From: Martyn White **On Behalf Of** Conservation Officer
Sent: 23 November 2018 10:56
To: Planning.Responses
Cc: Zac Denton
Subject: LU/262/18/L

LU/262/18/L

6, SOUTH TERRACE
LITTLEHAMPTON
MAISONETTE
SCALE 1:100 @ A4.

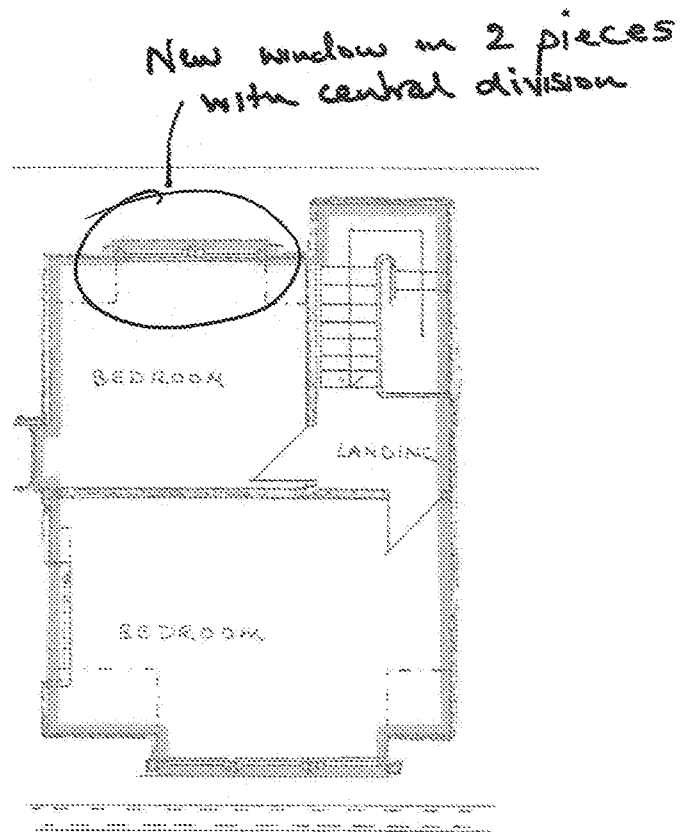
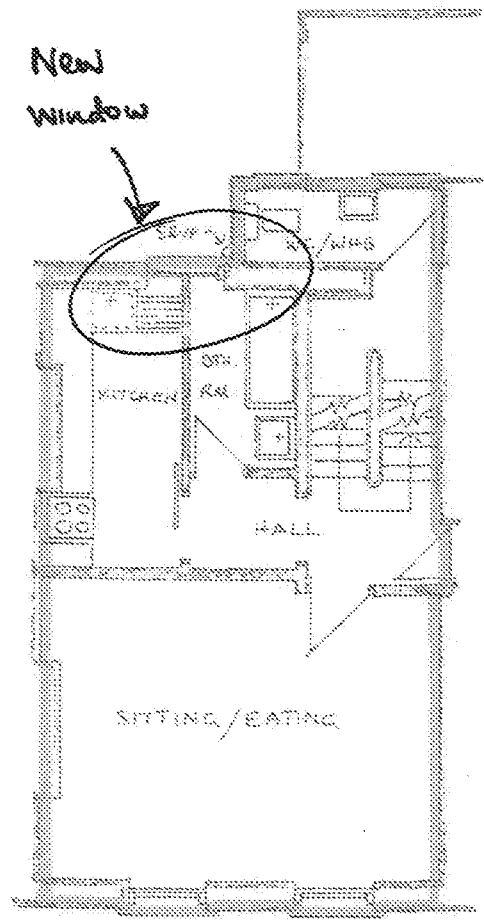
Windows are an important feature within a listed building, and their replacement should be carefully considered. Good practice is that existing windows should be retained and repaired prior to their wholesale replacement. I note that the application seeks permission not only for the replacement of windows, but ones constructed from UPVC. Such a proposal is problematic and cannot be supported.

The design, detailing and operation of windows constructed from UPVC make them appear different to traditional windows. Further, the visual effect of shiny modern plastic is out of keeping with more traditional materials.

As the application is retrospective, it is not known what the previous windows looked like, and if the replacement ones are a similar copy, or completely different. I should point out that replacing windows often offers the opportunity to install units which better reflect the character of the building, but it does not look as though this is the case with this application.
